Lime Down

Solar Park

Change Application and Consultation Report (Change Application)

Document Reference: EXAM/9.40

Drawing file: published-documents / EN010168-002736-6.2 ES Volume 2 Figure 13-11 Construction Access Locations Solar PV Sites (Rev 3).pdf

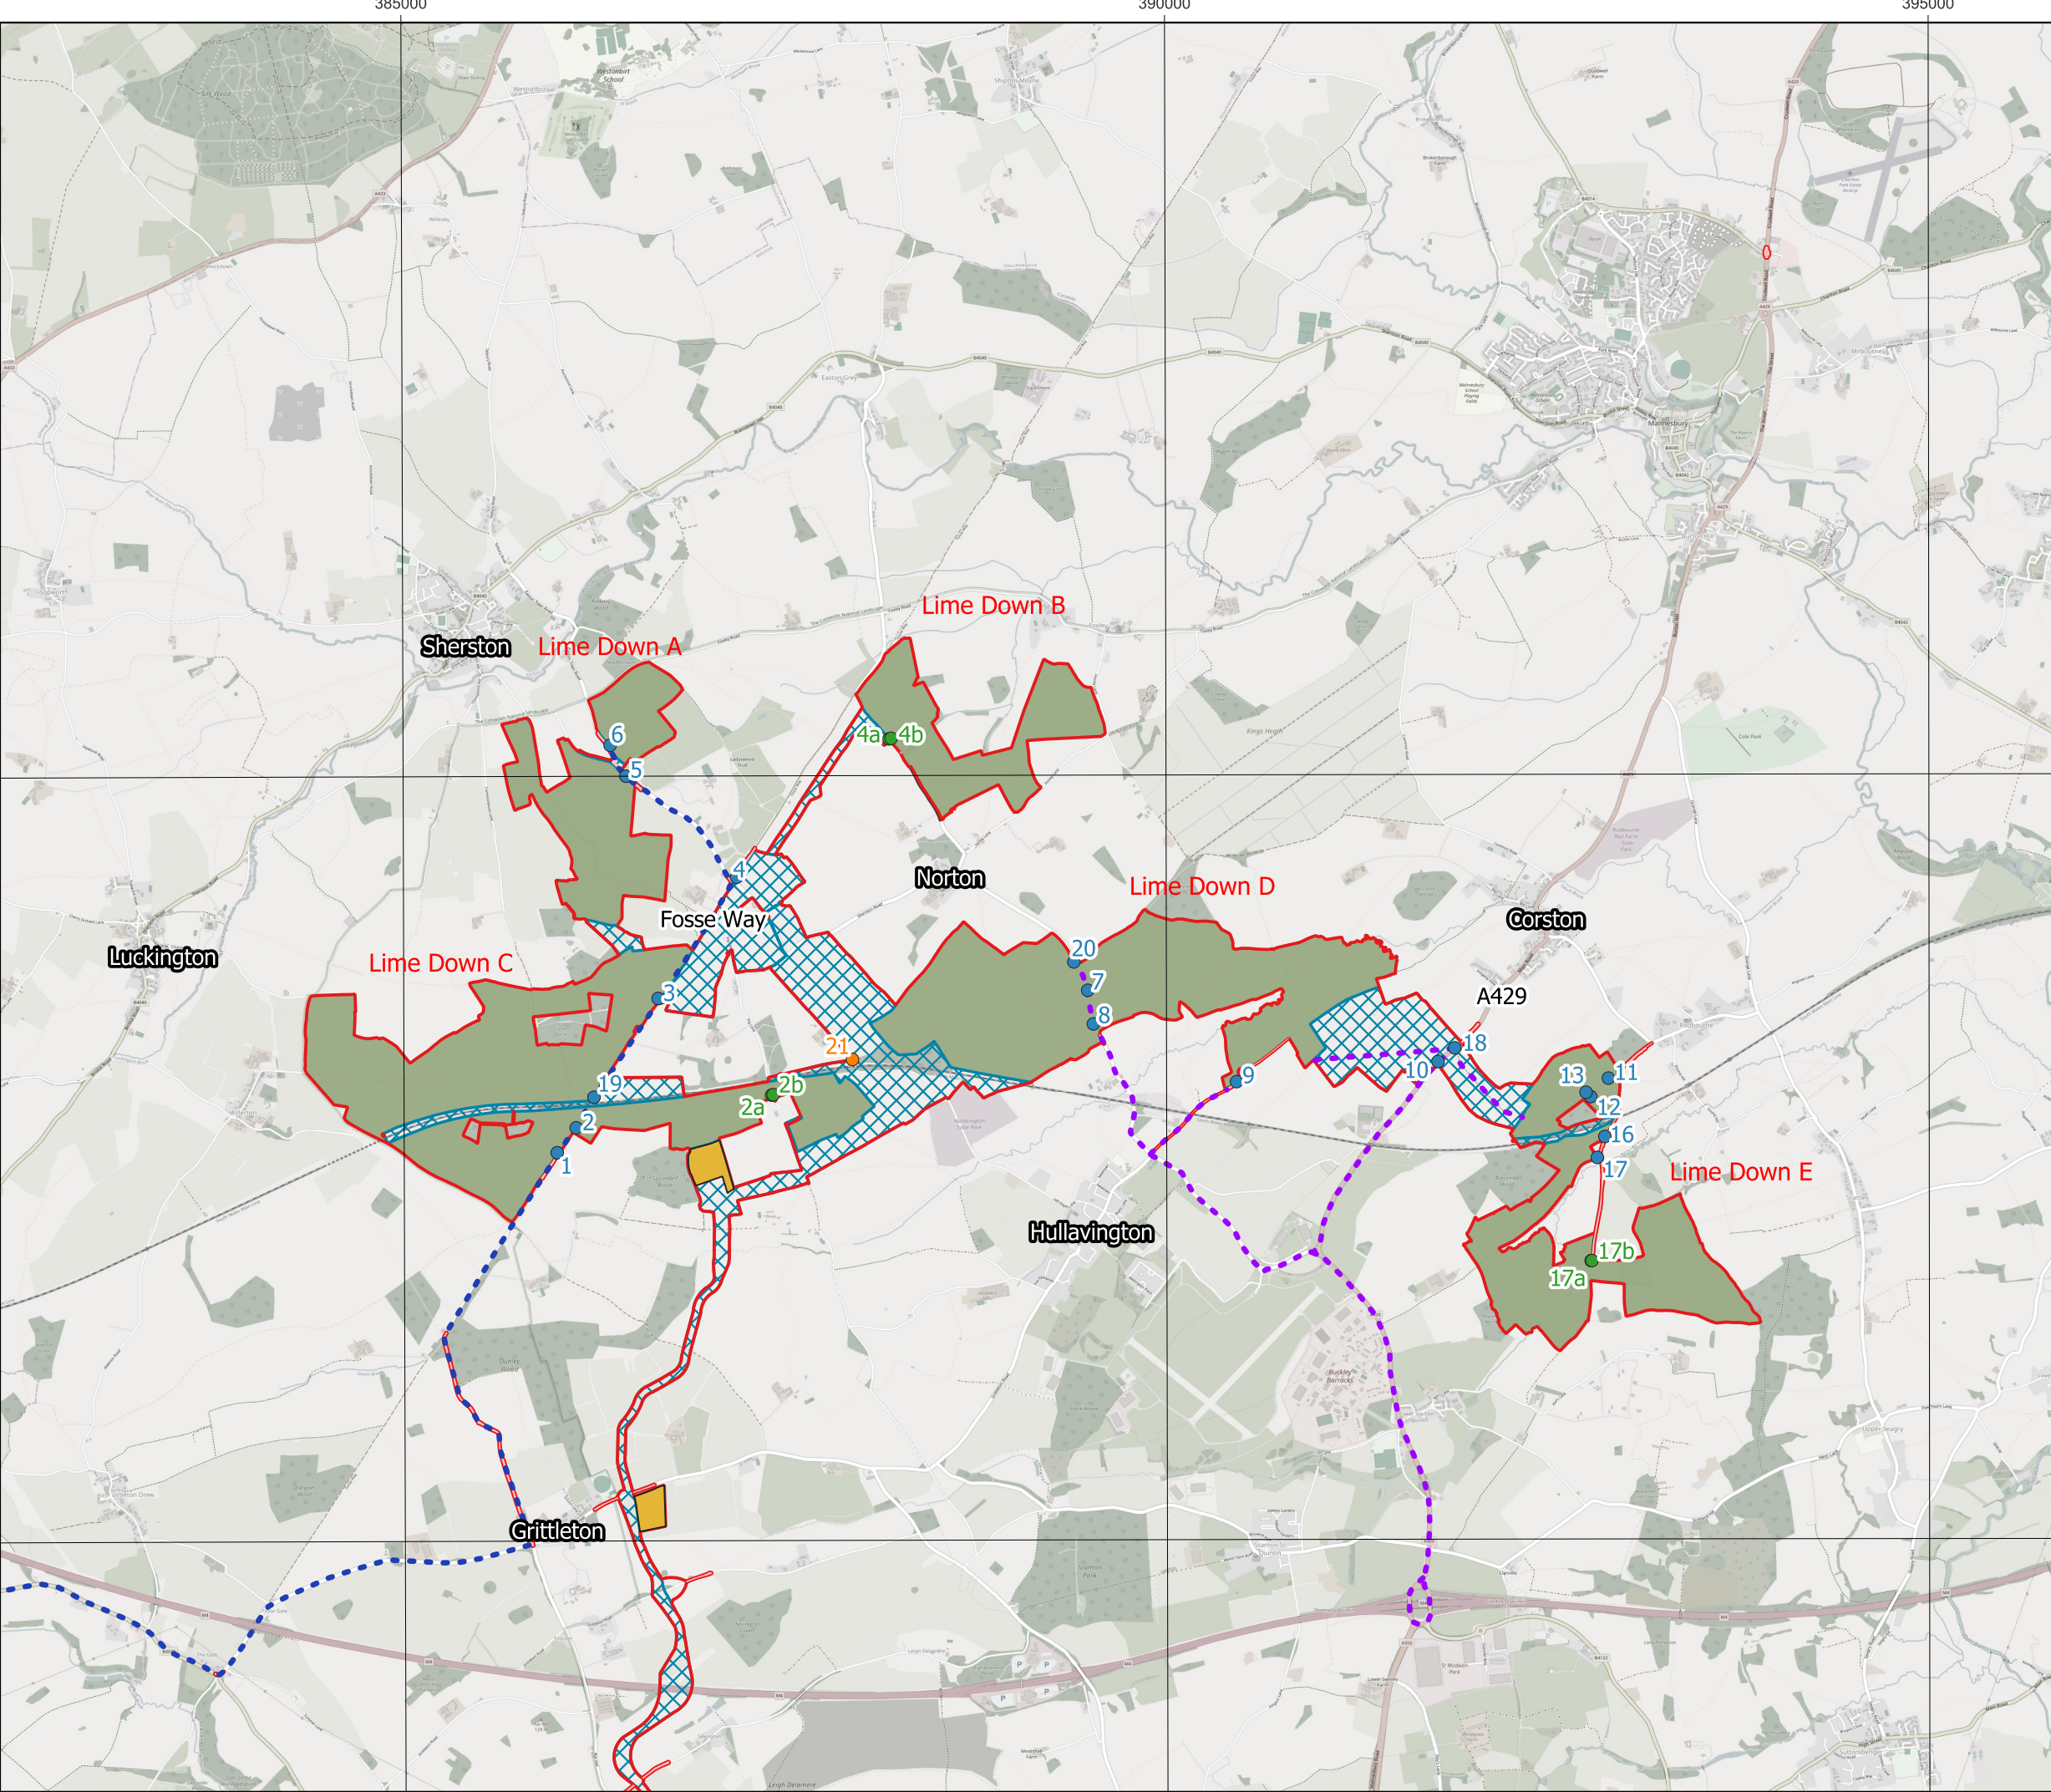
3.1.3 Change 1 comprises an extension to the Order Limits from the south western extent of the BESS emergency access (Access 21, as set out in Table 2 of the **Outline Construction Traffic Management Plan (CTMP) [REP3-108]**) at Lime Down D to the public highway named Hills Hayes Lane. A post-submission review by the Applicant of the Scheme accesses indicated that Access 21 did not adjoin the boundary of the public highway. This change will allow emergency Access 21 to tie into the public highway. The additional land will contain the bellmouth of emergency Access 21 which will comprise hardcore or gravel over a levelling layer of substrate. The additional land will be subject to Work Number 8b.
